**KIRKLEES METROPOLITAN COUNCIL
INVESTMENT & REGENERATION SERVICE**

**DELEGATED DECISION FOR APPLICATION FOR CERTIFICATE OF
LAWFUL DEVELOPMENT**

Reference no.: 2025/CL/90422/W

Description: Certificate of lawfulness for proposed erection of
single storey side extension and outbuilding

Proposed Block Plan

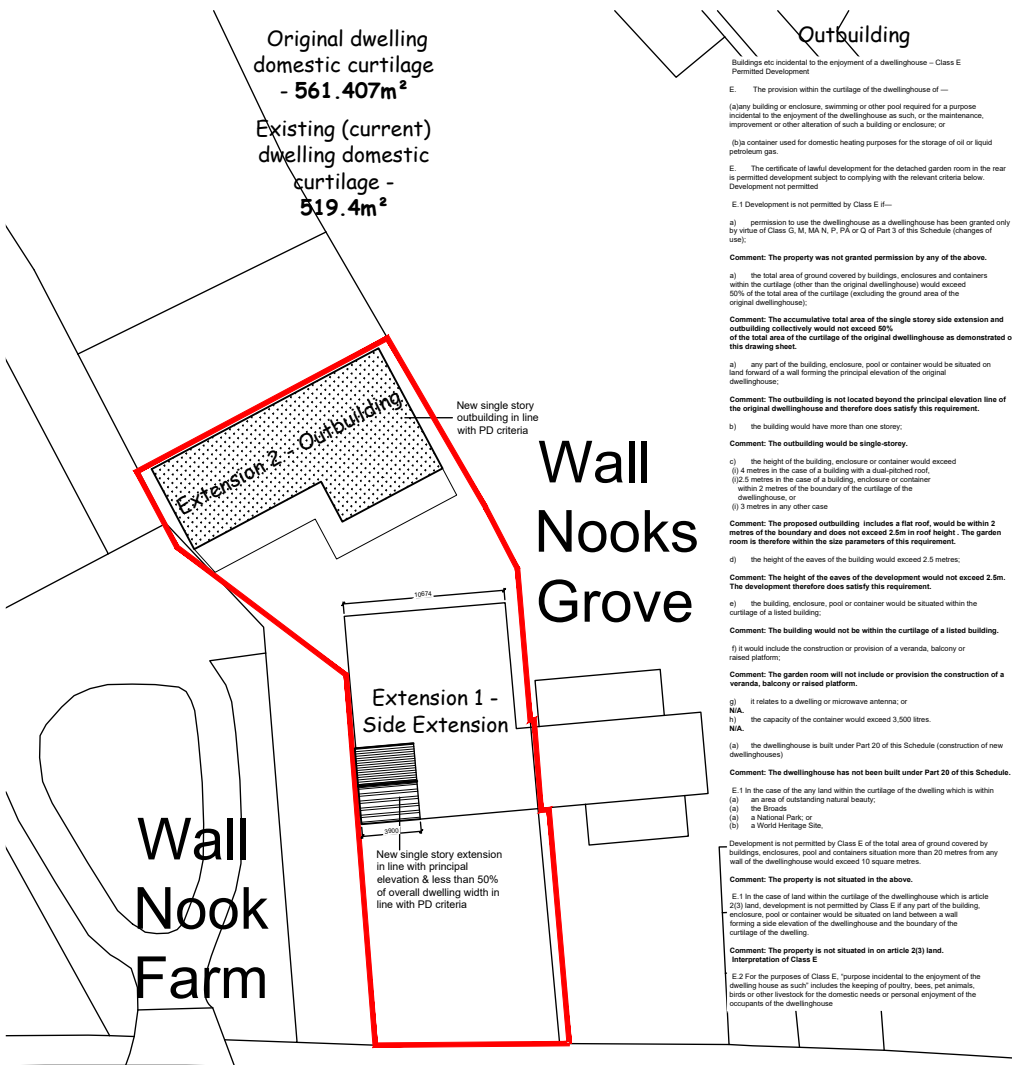
Comment: *Historical imagery held by the Council indicates the existing stepped arrangement to the front of the property existing before and after 1948 and is thus original to the dwellinghouse as defined in the Order. The enlarged part of the dwellinghouse would therefore extend beyond a wall which forms the principal elevation of the original dwellinghouse, although it does not extend beyond a wall which fronts a highway and forms a side elevation of the property.*

The single storey side and front extension does not benefit from a general planning permission granted under Schedule 2, Part 1, Class A of the Town and Country Planning (General Permitted Development) (England) Order 2015 (as amended) as the enlarged part of the dwellinghouse would extend beyond a wall forming the principal elevation of the original dwellinghouse contrary to A.1 (e).

Outbuilding as Proposed

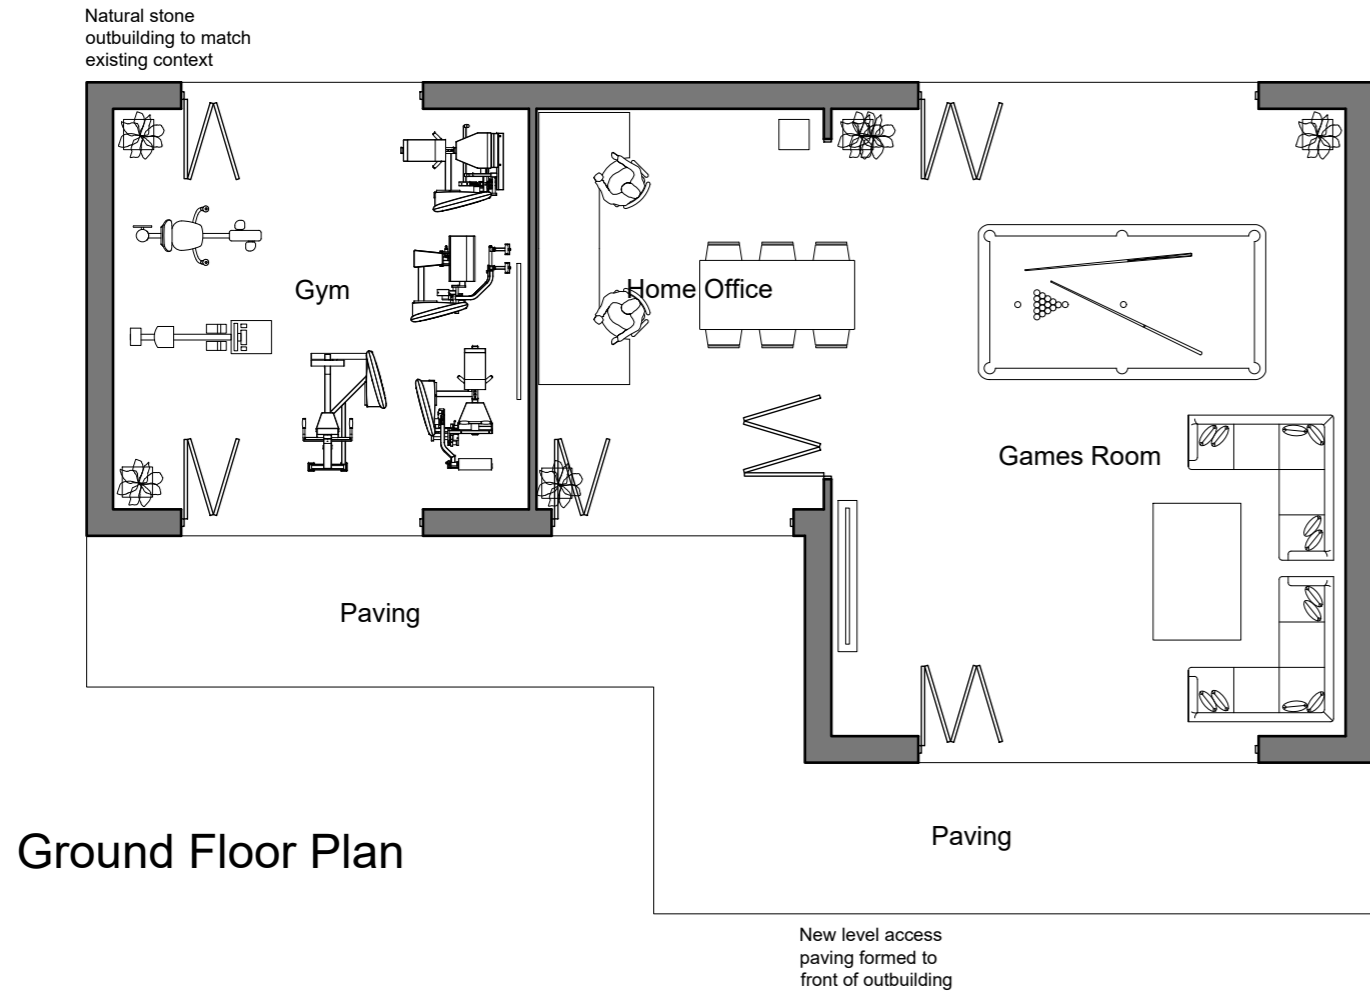
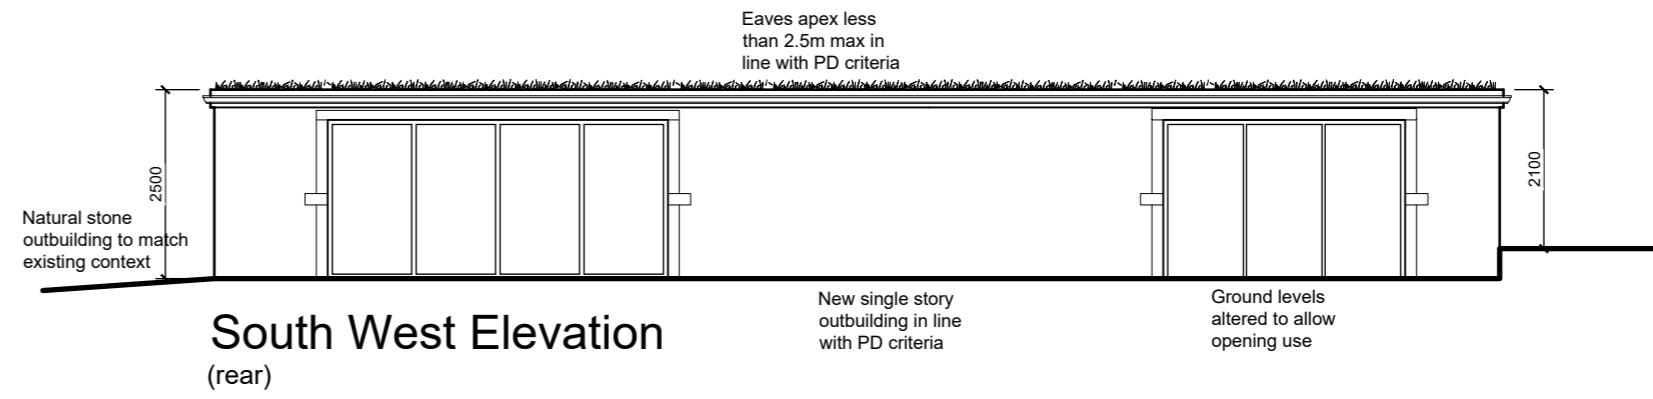
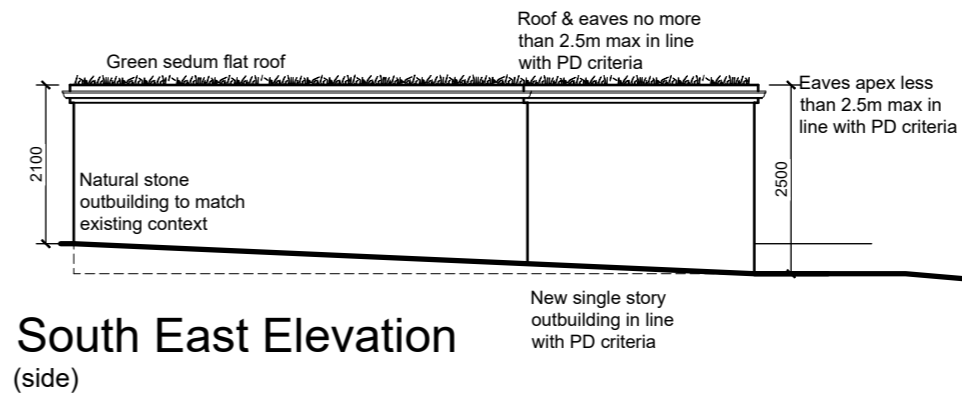
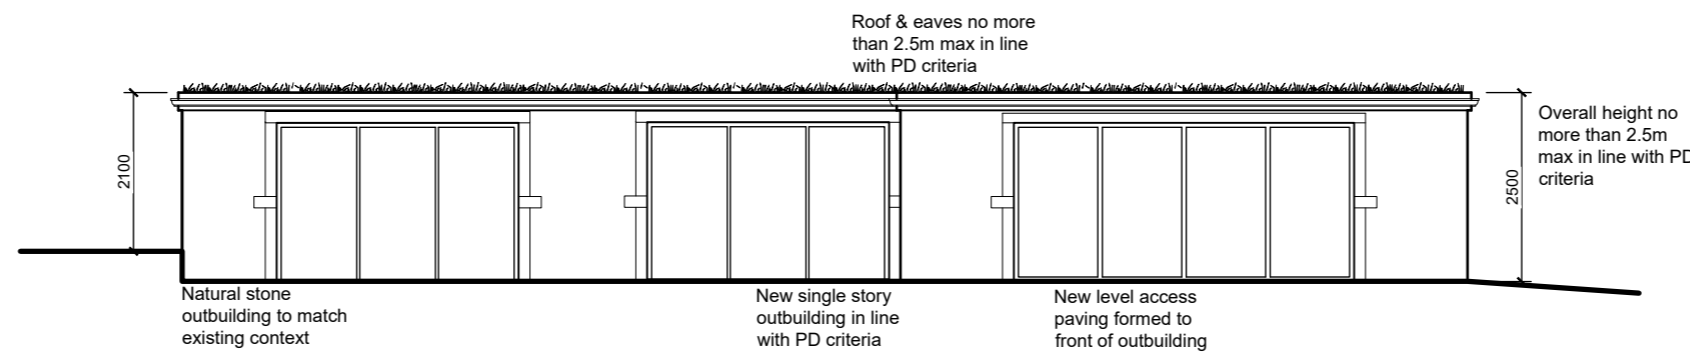
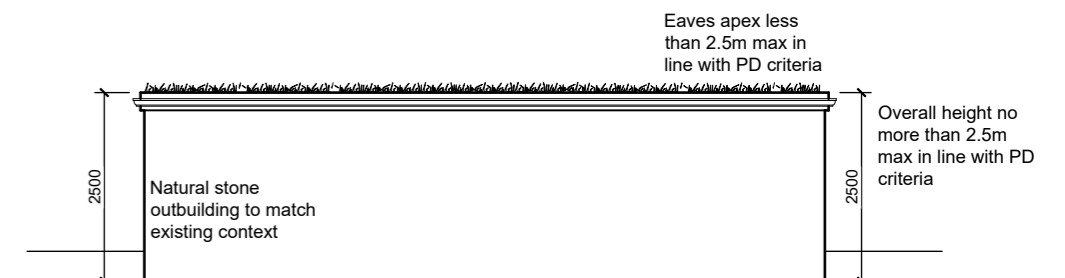
The proposed outbuilding is stated on the submitted plans as being 134 square metres. When measuring the original building against the original building (prior to the construction of the single storey rear extension and porch), the footprint of the original building was approximately 96 square metres and therefore, the additional built development of just the outbuilding alone (without any other additions) would equate to an approximate of 139% increase in floor space for the property.

The submitted details indicate that the outbuilding would accommodate a gym, games room and home office which in principle may be considered incidental to the enjoyment of the dwellinghouse.

However, combined the gym would have internal dimensions of 5.5m x 5.1 metres and the home office and games room has an internal width of approximately 10.6 metres and maximum internal depth of 8.4 metres. There has been no justification as to the size of the building and that the proposed accommodation is reasonably required for the enjoyment of the dwellinghouse.

The overall size and use of the outbuilding is considered to go beyond that which is incidental to the main dwellinghouse. The plans indicated that lounge area which demonstrates images of a lounge area and TV, which offers primary living accommodation which is not considered incidental to the enjoyment of the dwellinghouse and appears to be an extension to the existing living

The area shown as home office suggests space for two home workers and a large table seemingly there for work purposes. While it is no uncommon for people to work from home, this would typically be space confined to a small desk or work area within existing living space. In this instance the home office goes beyond a small desk or work space and includes other furniture which appear to be also dedicated work areas which could likely be used to host work meetings leading to visitors to the property for working purposes. This use is not therefore considered to go towards the reasonable incidental enjoyment of the dwellinghouse.

In this instance the applicant has not demonstrated that the large outbuilding hosting a gym, large area for home working, primary living space and games room. The area for home working is significantly large to be considered subordinate or reasonable to the needs of a typical home worker with the lounge area appearing to be an extension to primary living accommodation already available in the main dwellinghouse. The applicant has not provided any evidence to demonstrate the areas shown for uses in the circumstances of this particular case are reasonably necessary or required for the enjoyment of the dwellinghouse.

Therefore officer cannot therefore accept all the space within the building is reasonably required for purposes incidental to the enjoyment of the dwellinghouse.

The proposed erection of an outbuilding is not considered to benefit from a general planning permission under the provisions of Class E, Part 1 of Schedule 2 of the Town and Country Planning (General Permitted Development) (England) Order 2015 (as amended) as it has not been demonstrated the building is required for purposes incidental to the enjoyment of the dwellinghouse.
